**STATEMENT OF ENVIRONMENTAL EFFECTS: SECTION 75W APPLICATION TO MAJOR
PROJECT MP NO.10_0107 STAGE 1 (BUILDINGS 1 AND 2) – 61 MOBBS LANE, EPPING**

Pursuant to Section 75W (1) (a) of the Environmental Planning and Assessment Act 1979, a 'modification of approval' is sought to vary Condition No. A2 pertaining to Major Project MP No. 10_0107 as approved on the 17 January 2011. Various modifications are sought to address market demand and construction details applying to Buildings 1 and 2. The changes do not alter the height, bulk or scale of the approved development.

B1 Elevations (A1005) Rev A – North Elevation

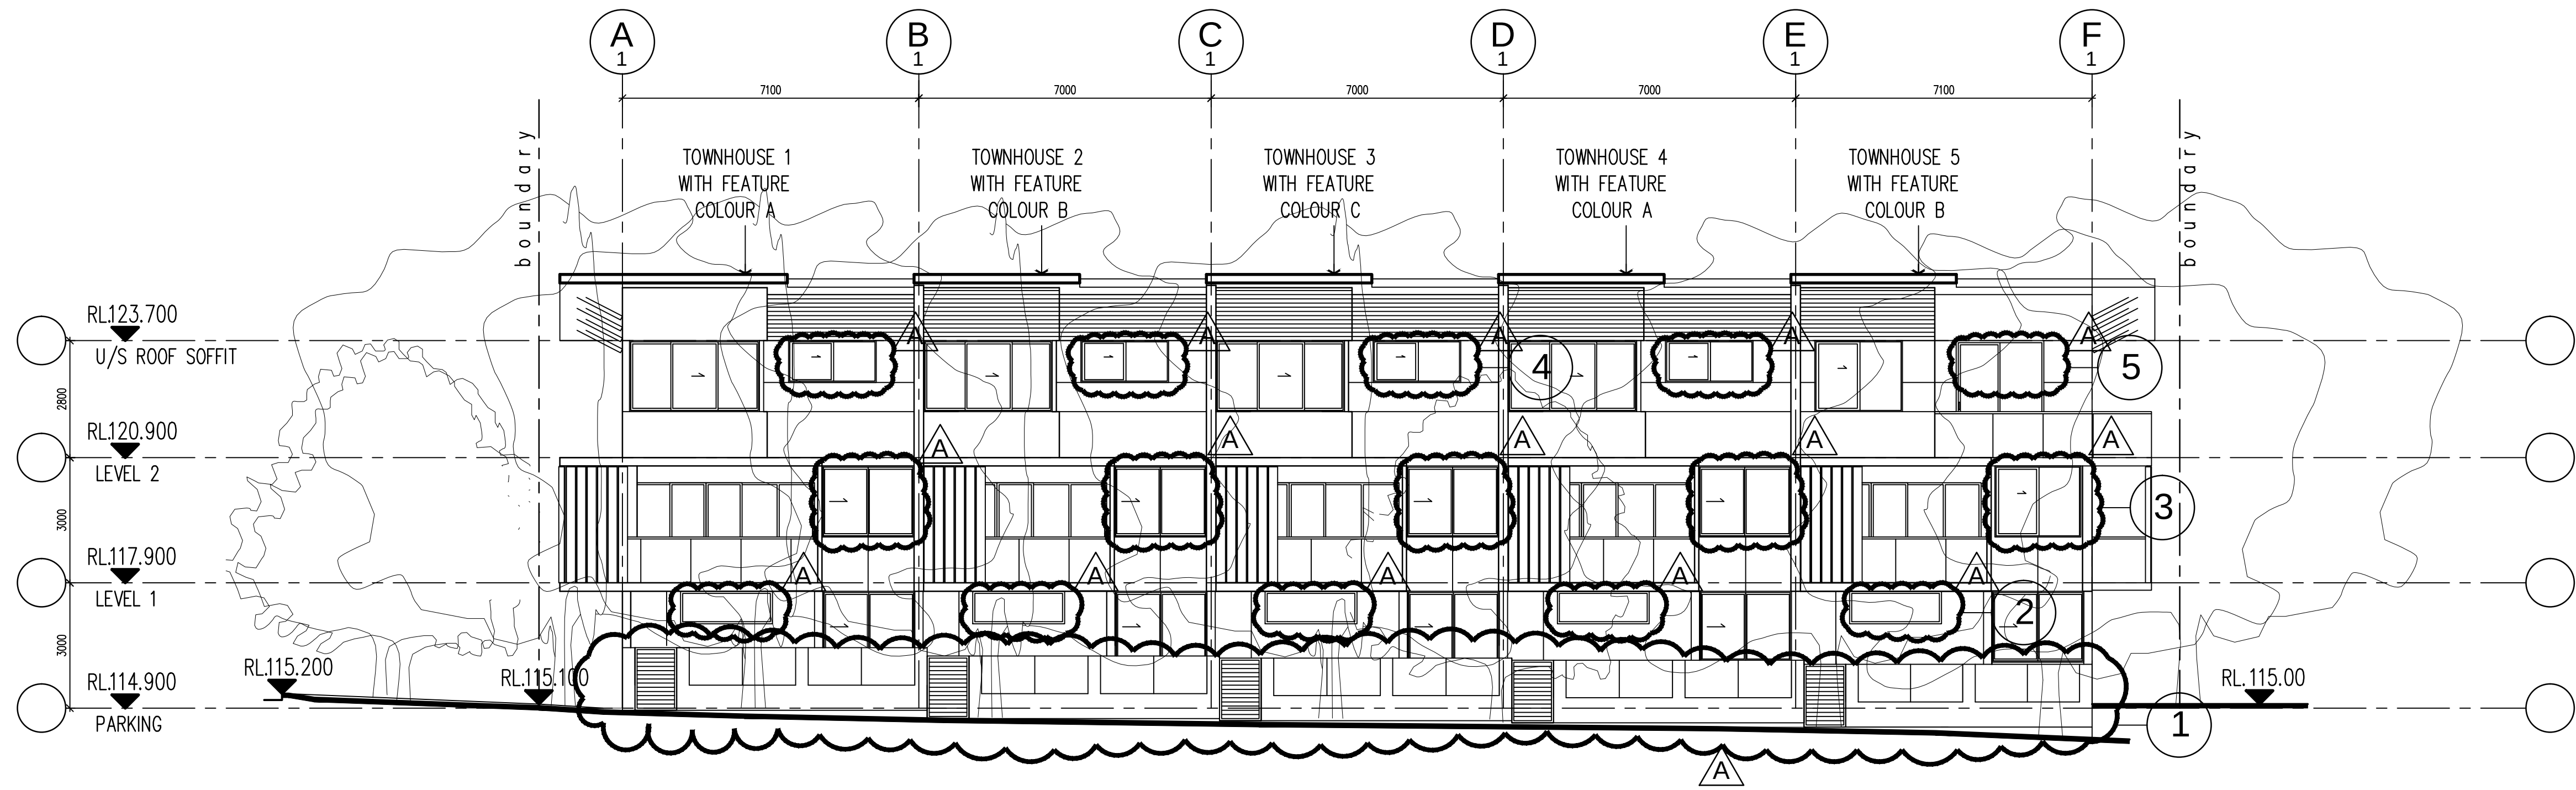
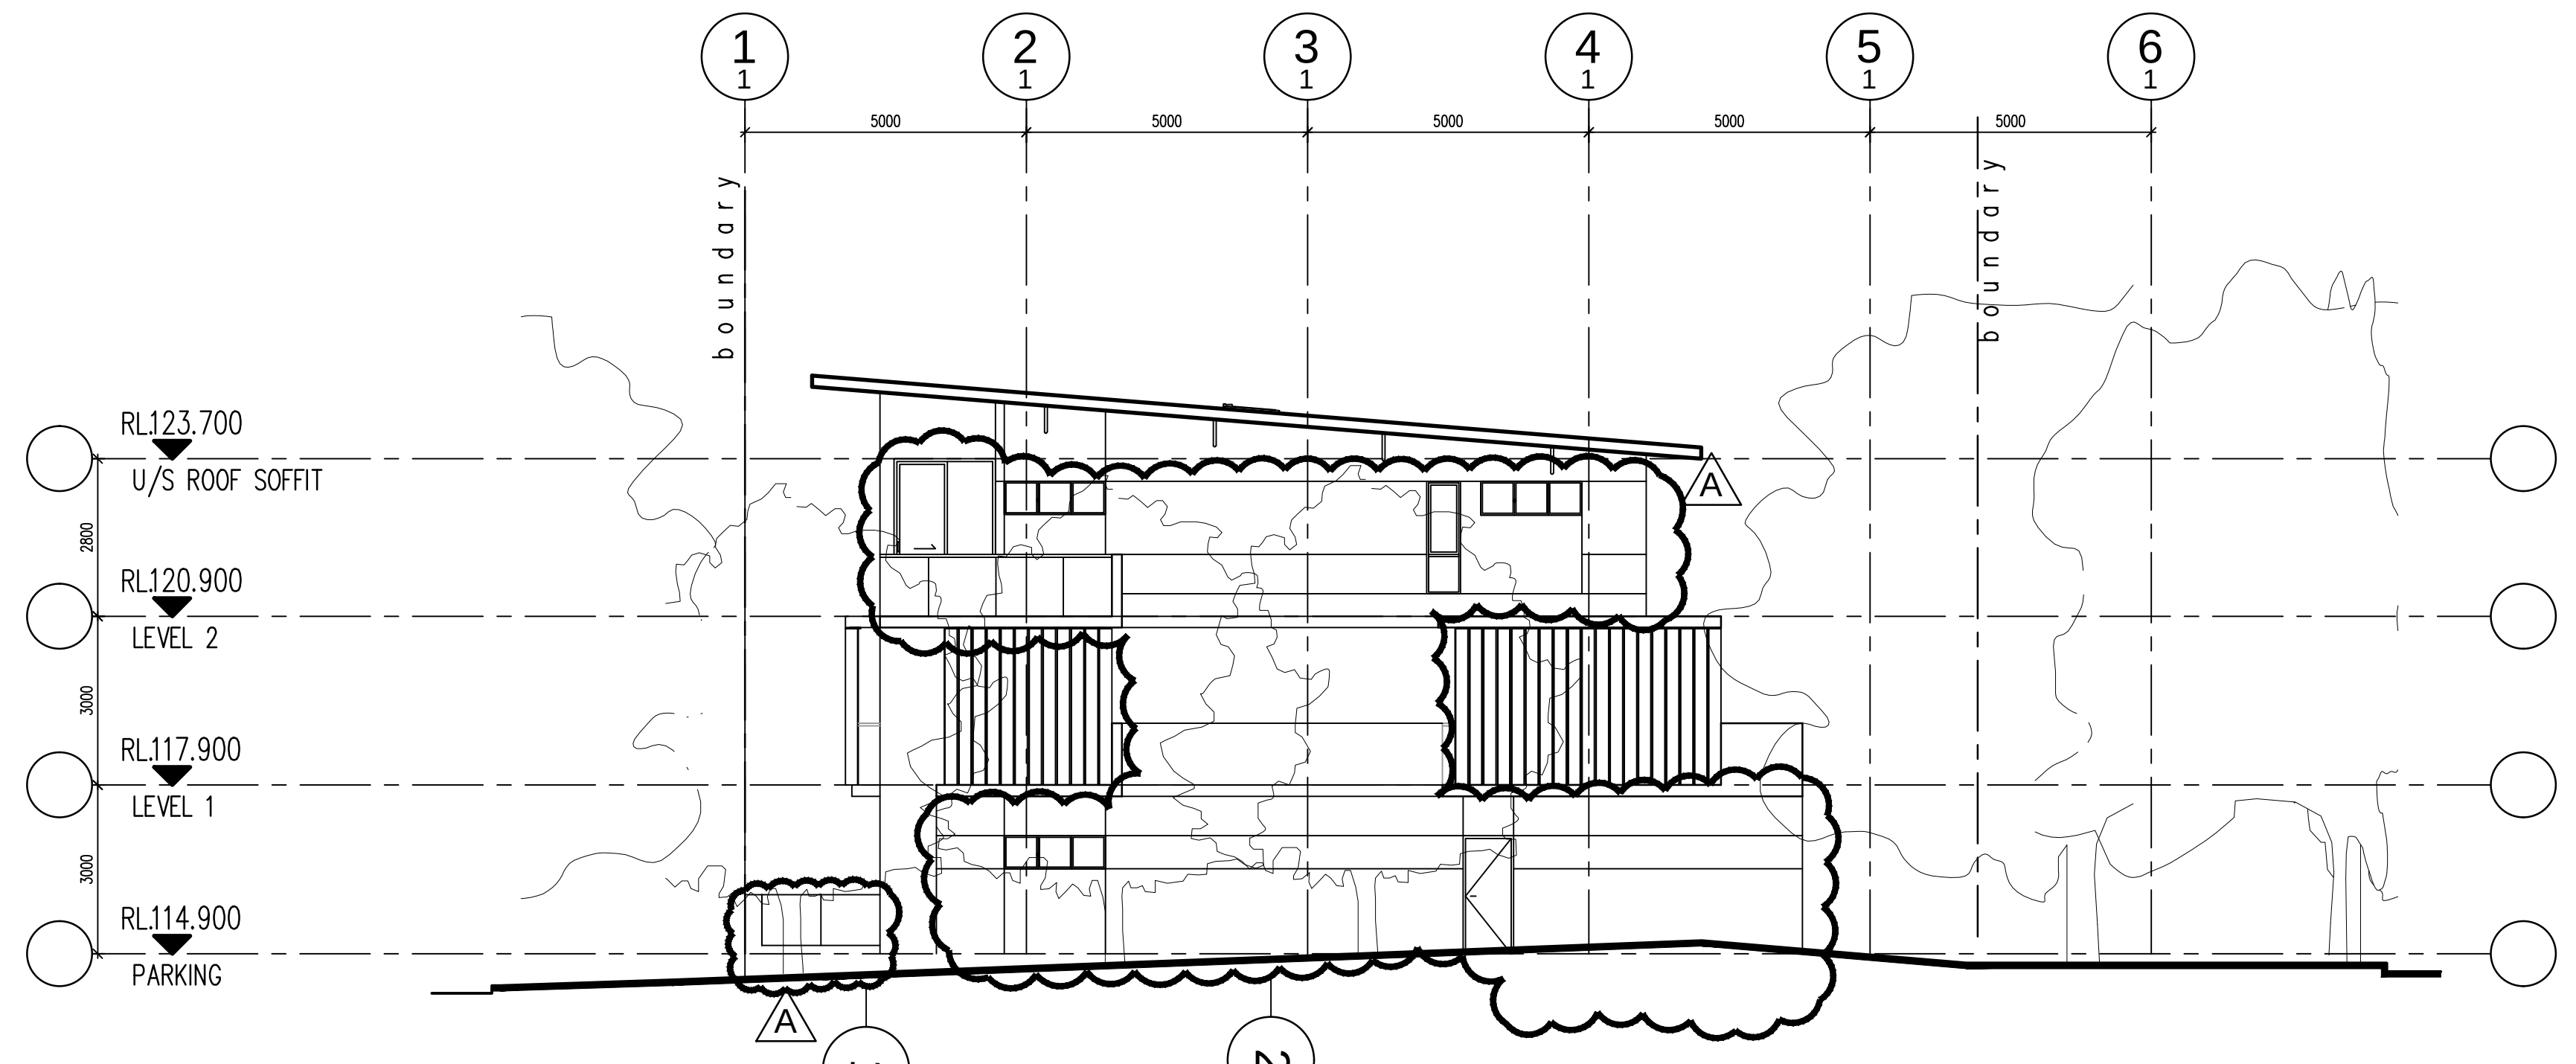
1. New glass and masonry courtyard fence 1.8m.
2. New highlight window units 1 – 5.
3. New window configuration units 1 – 5 (Level 1).
4. New window configuration units 1 – 4 (Level 2).
5. New sliding door – unit 5.

1. Sliding doors reconfigured in units 1 – 5 and frameless glass balustrades.

B1 Elevations (A1005) Rev A – West Elevation

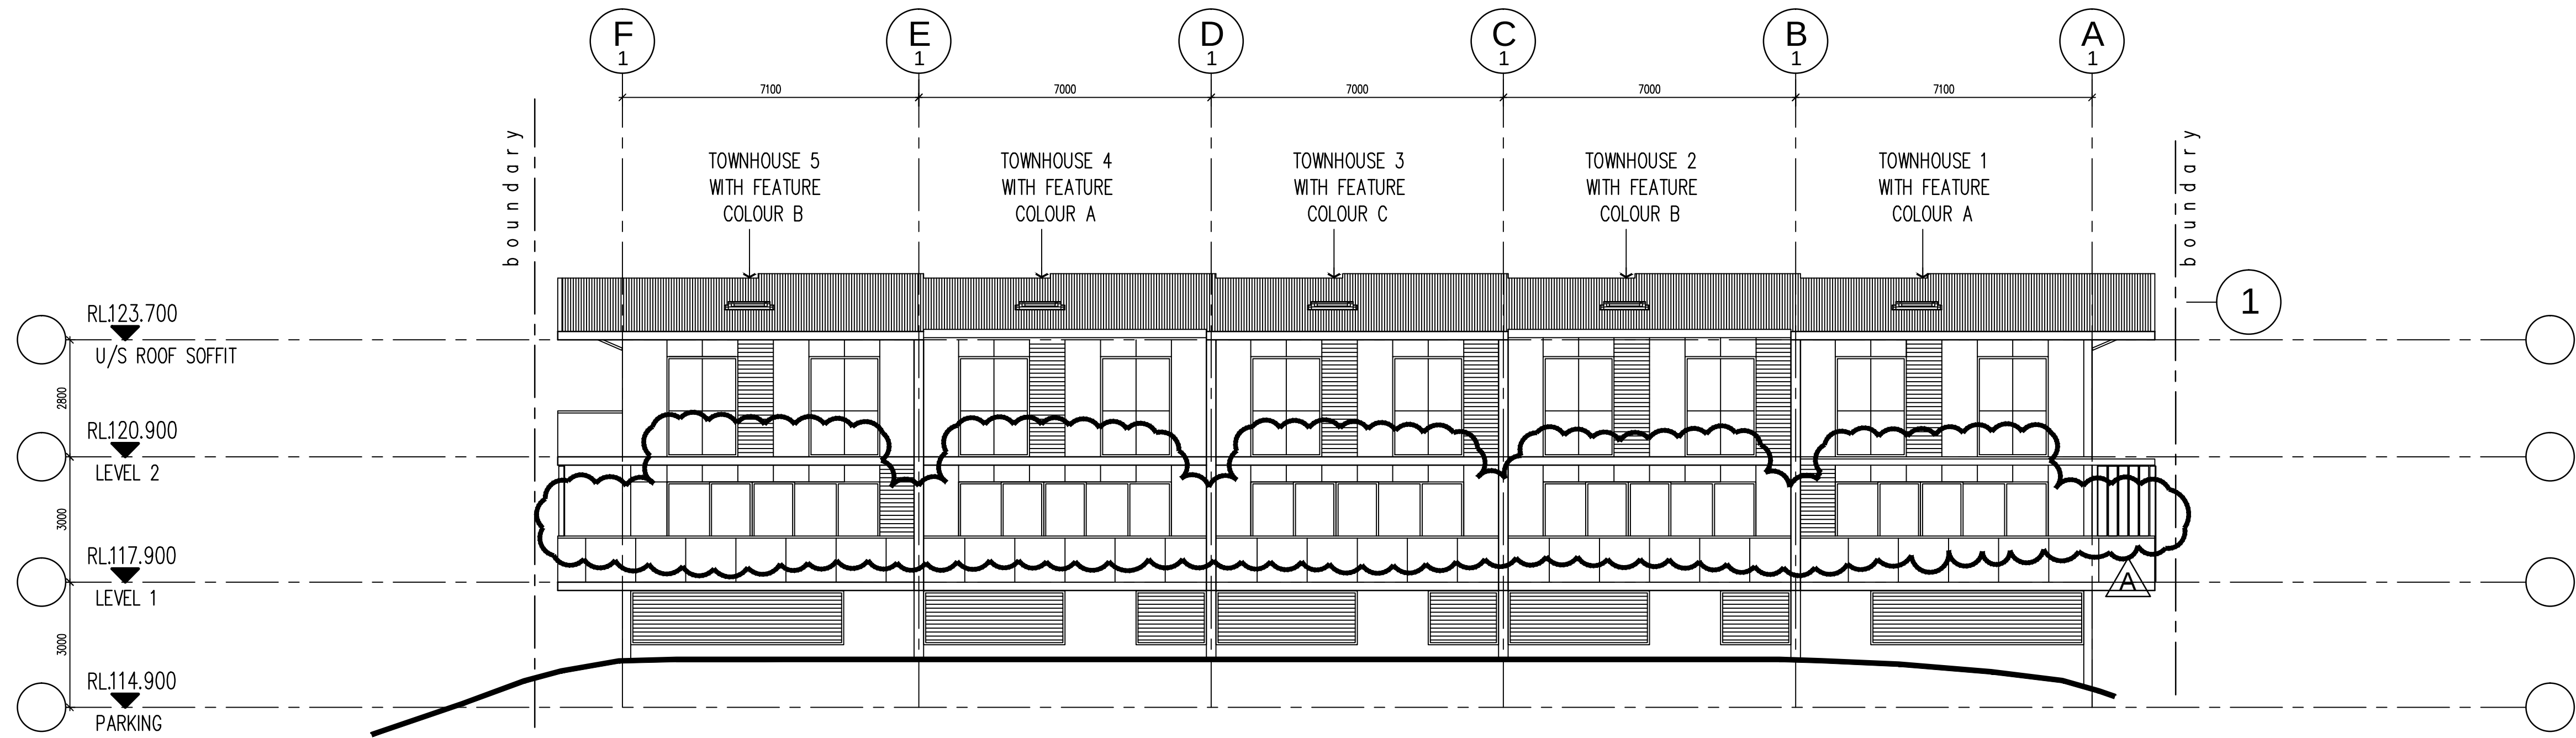
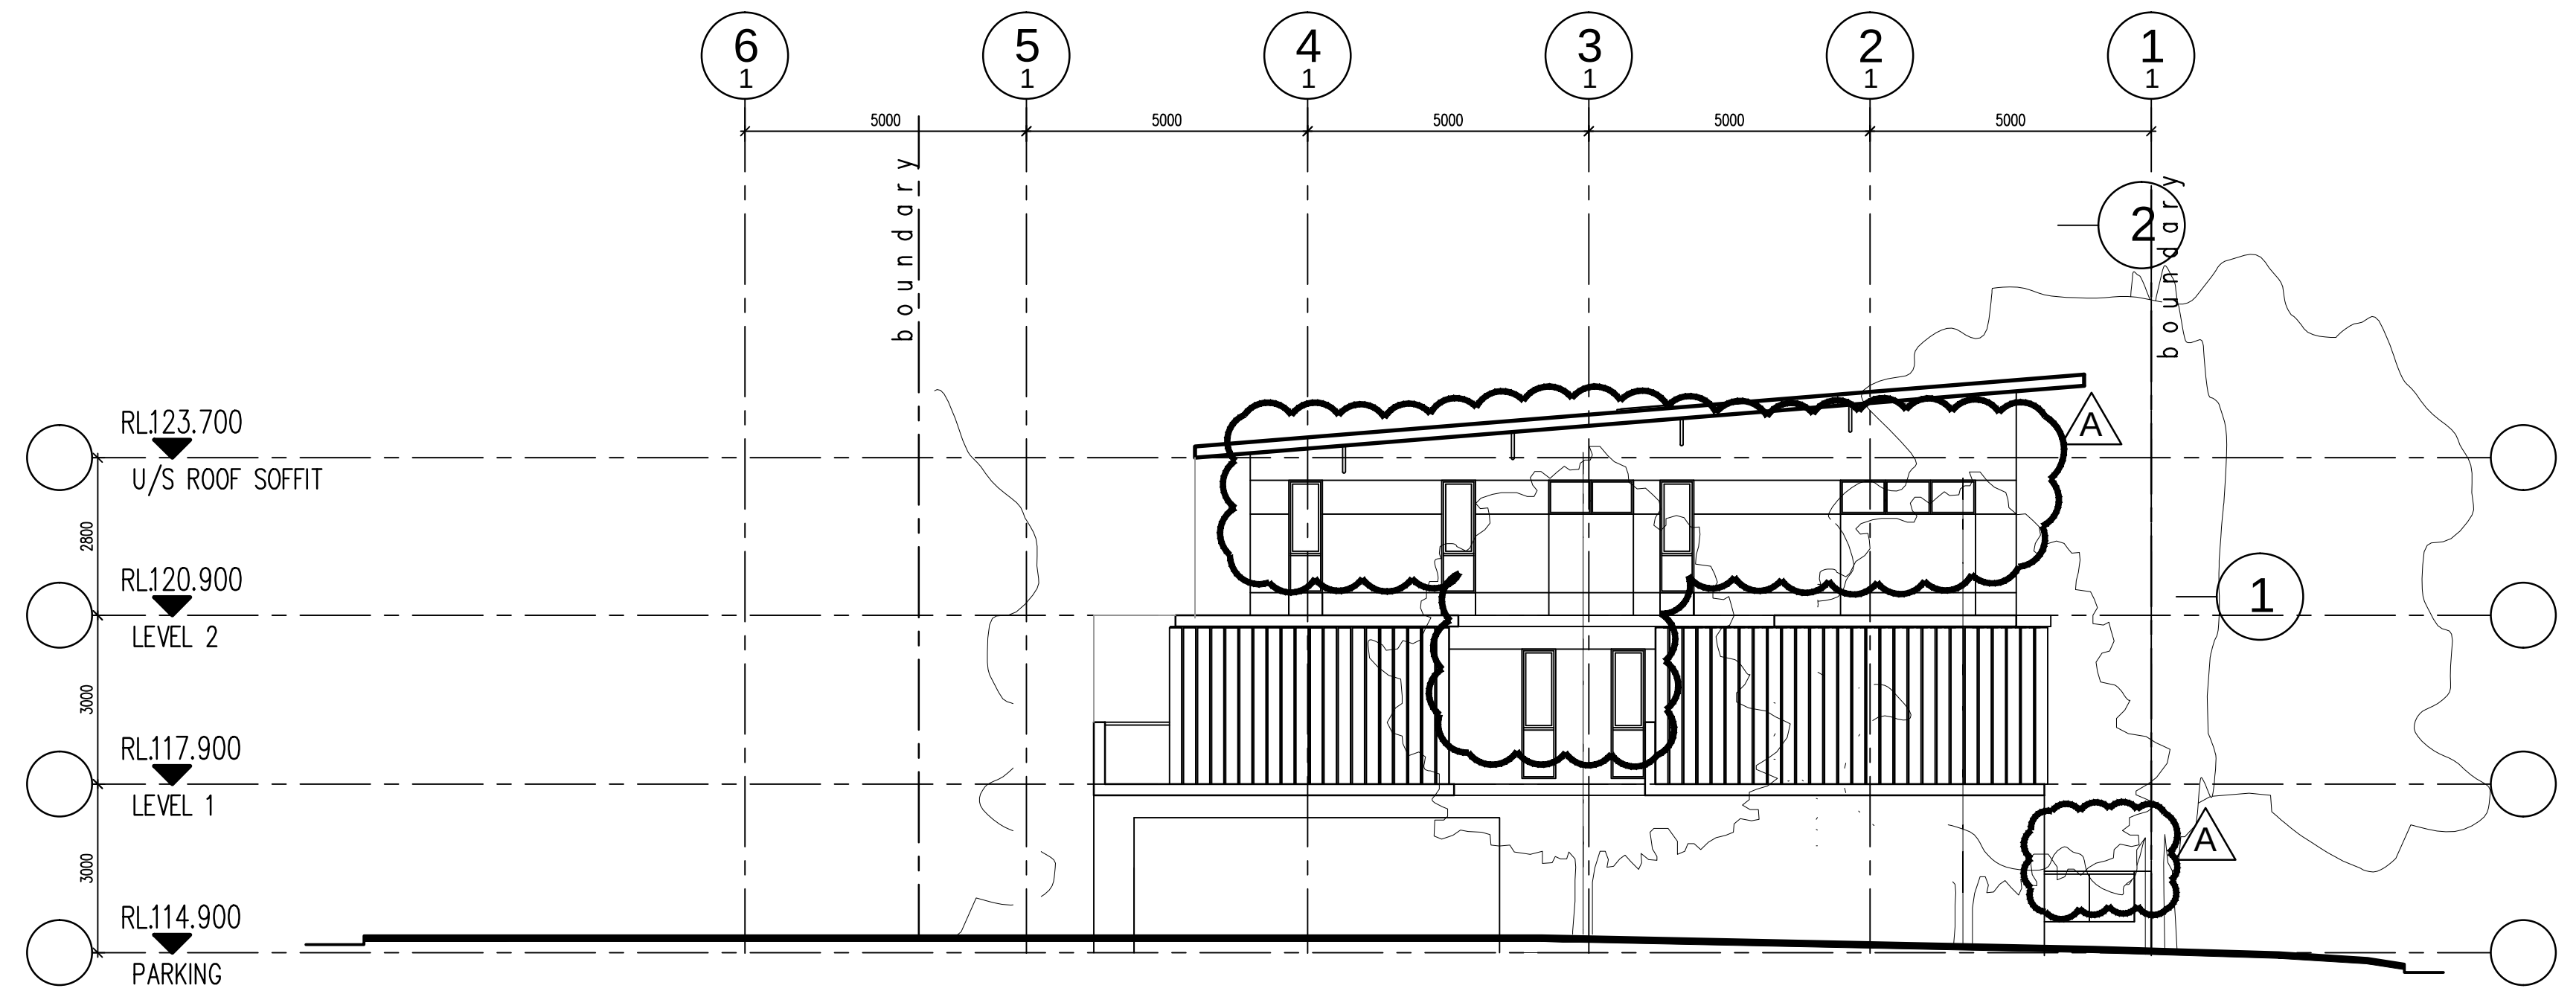
1. New glass and masonry courtyard fence 1.8m.
2. Additional grooves in wall (all levels) and new window configuration.

1. New glass and masonry courtyard fence 1.8m.
2. Additional grooves in wall (all levels) and new window configuration.
